DECISION DELEGATED TO HEAD OF PLANNING

Application No: H18-0936-25 **Applicant:** Mr & Mrs Grundy

Proposal: Demolition of existing agricultural building (with Class Q prior approval H18-0314-25) and erection of 2 storey 4 bed dwelling

Location: 185 Avenue Farm Road Sutton Bridge Spalding

Site Plan
Scale: 1:200

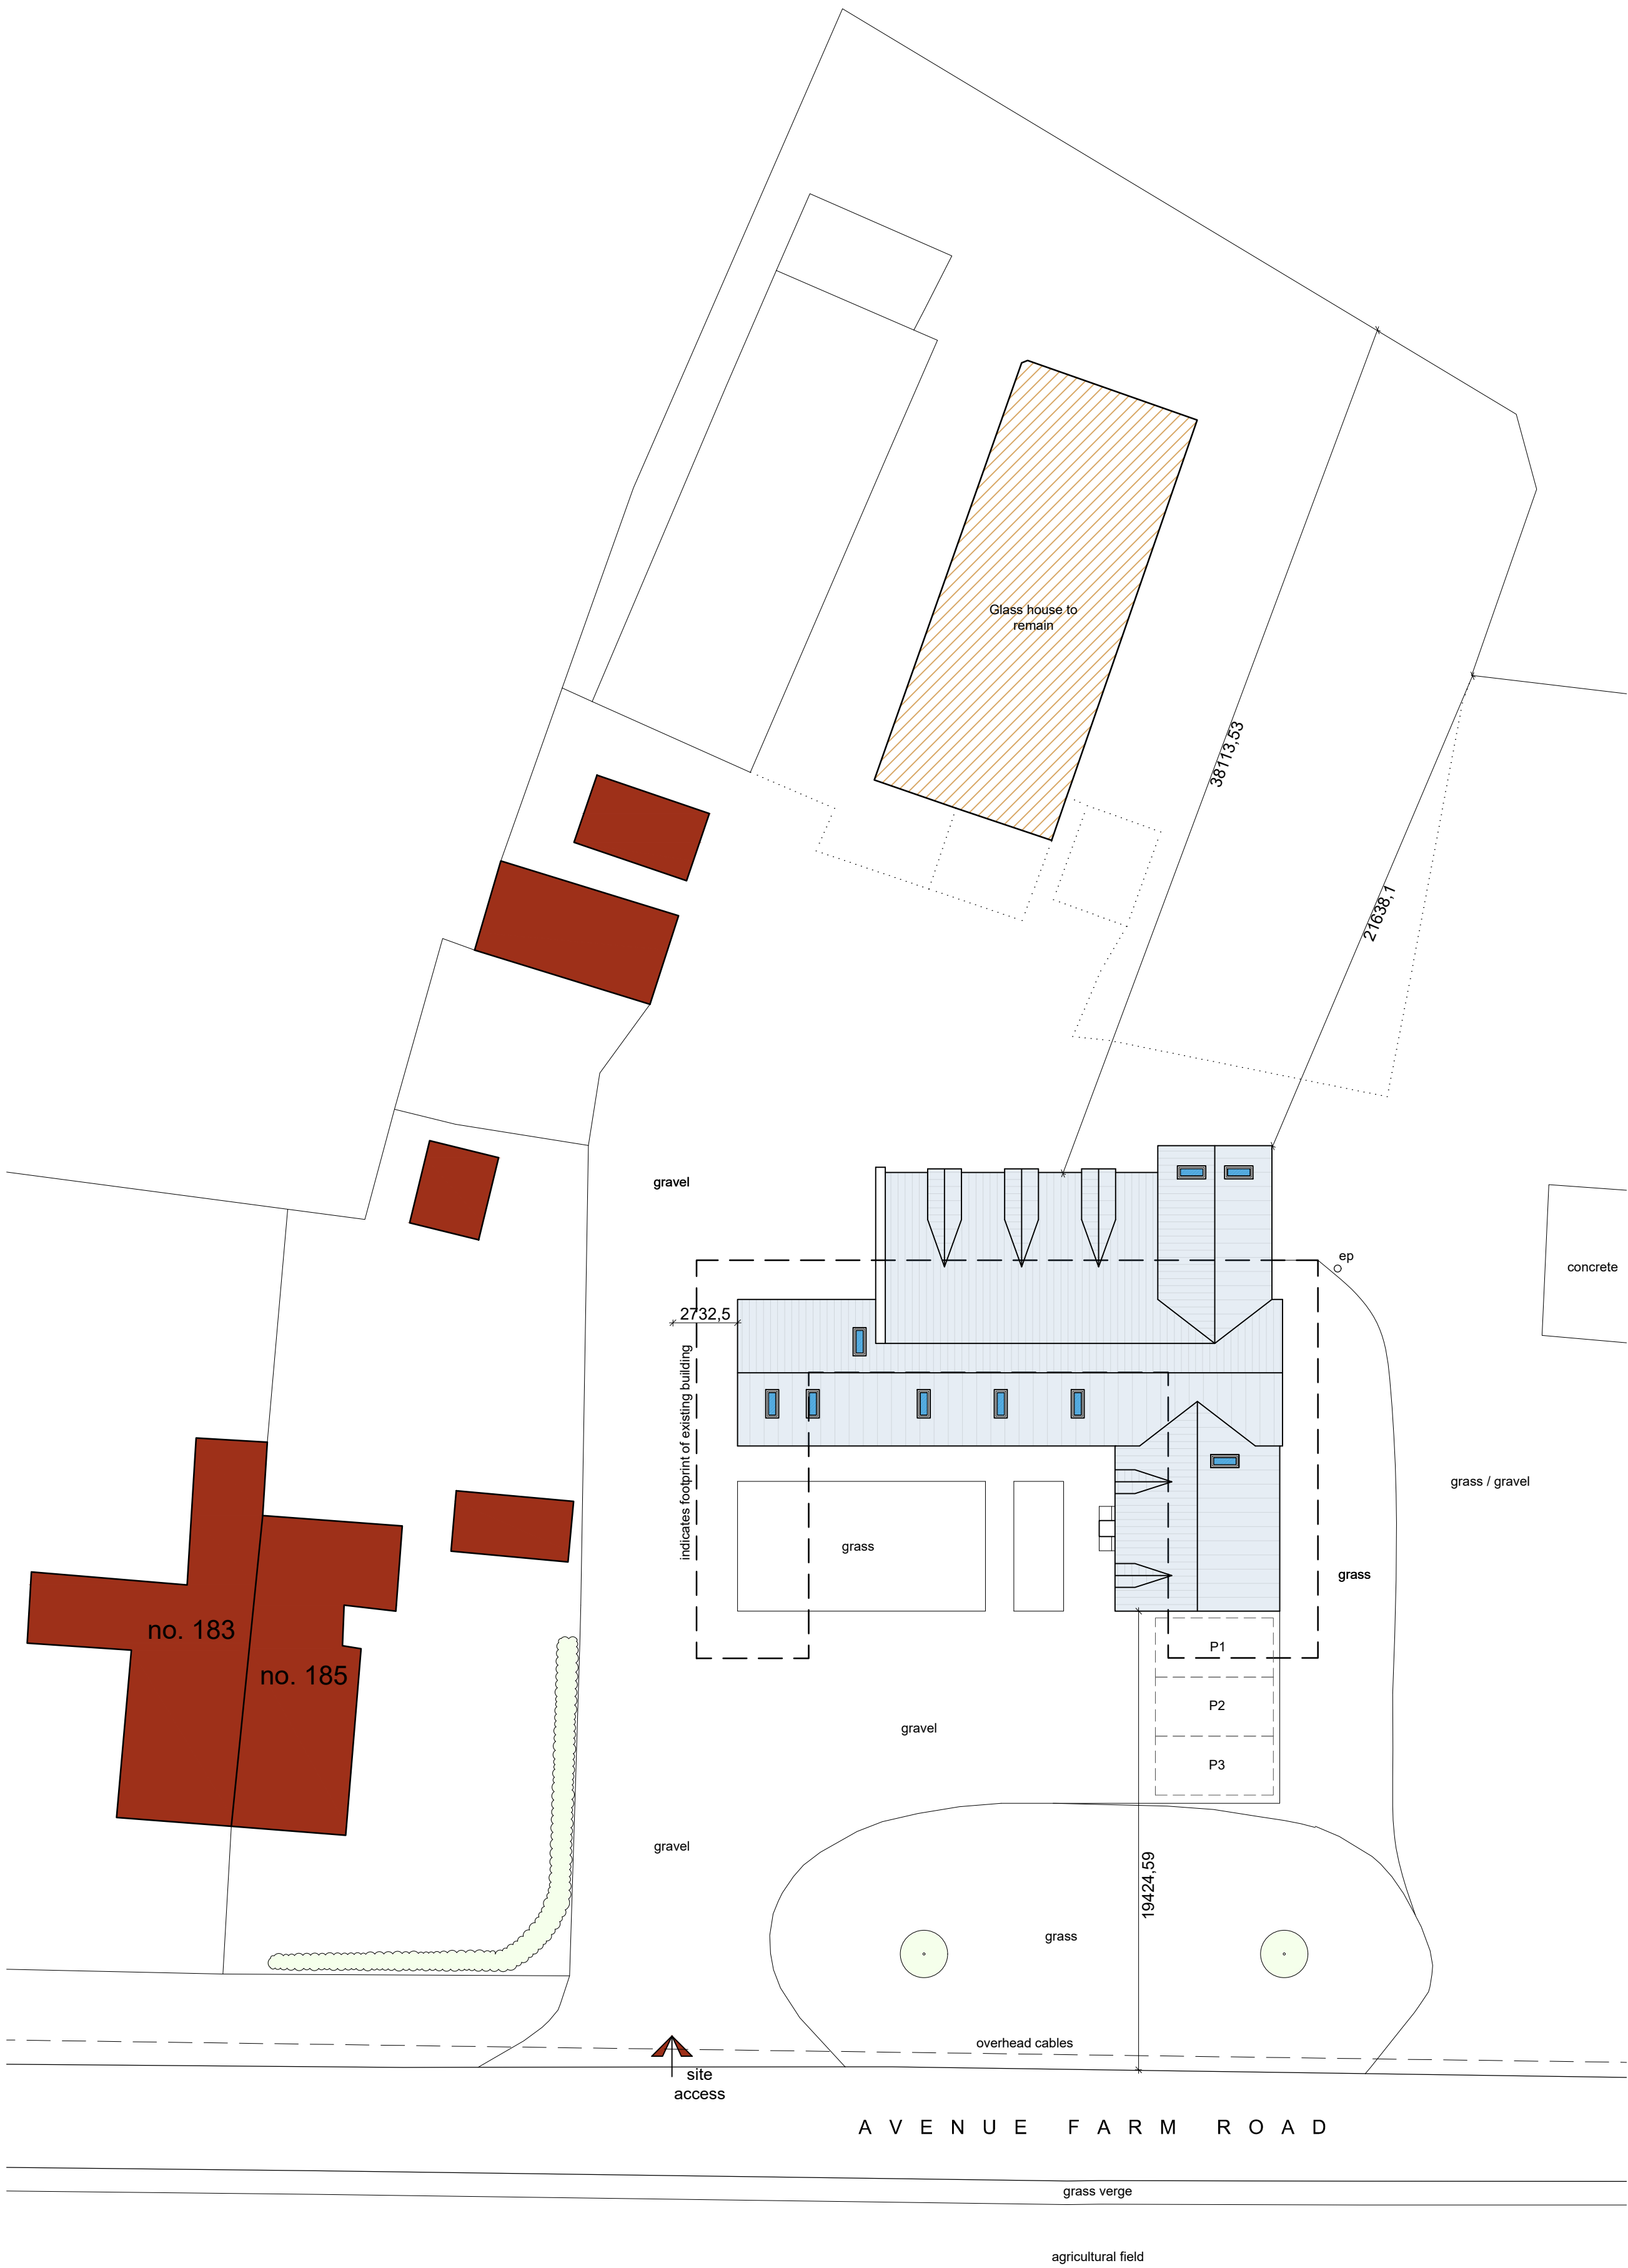
One of the considerations for betterment is whether the new proposal would enhance the setting of the area. In this case, the site is mostly surrounded by flat and open agricultural land, though there are 2 dwellings located to the west of the site. Therefore, the site is set within a countryside setting. The Class Q conversion proposed to retain the form, siting and general appearance of the building within the site, all of which has been informed by the open countryside context of the site. Furthermore, the approved red line boundary from the Class Q conversion application was much smaller than the current red line boundary. It is unclear where the garden space is proposed under the current proposals; however, based on the red line boundary the garden area could be significantly larger than under the Class Q conversion.

The scale and bulk of the proposed new dwelling would be significant compared with the approved Class Q conversion. It is considered that the multiple, competing roof forms and overall bulk of the dwelling would result in poor design that would be incongruent within the surrounding landscape. The submitted Design and Access statement fails to justify the design rational in terms of its appropriateness to this location. Whilst some additional information has been provided by the applicant's agent regarding the design, it is not considered that this sufficiently justifies the proposal.

The proposed design does not appear to be based upon any contextually related design traits that are inherent in the existing barn or the approved conversion. It is not considered that the proposal would enhance the setting of the area. The increased residential curtilage could even potentially result in more visual harm if residential paraphernalia is installed, given that this does not require planning permission.

It is considered that through the siting, orientation, footprint and form of the proposed development, this would result in a more urbanising effect upon this part of the countryside than the Class Q consent. This is considered to result in more harm to the character and appearance of the area than the previous approval. Furthermore, the applicant has failed to demonstrate a clear or overriding justification as to why such a design should be considered acceptable in this location. Therefore, it is not considered that the proposed design represents betterment over the Class Q conversion, which was a more sympathetic and appropriate design, particularly given the rural and open countryside character of the site. As such, the proposal is considered to be contrary to the aims of Policies 2 and 3 of the Local Plan, and Paragraph 187(b) of the NPPF.
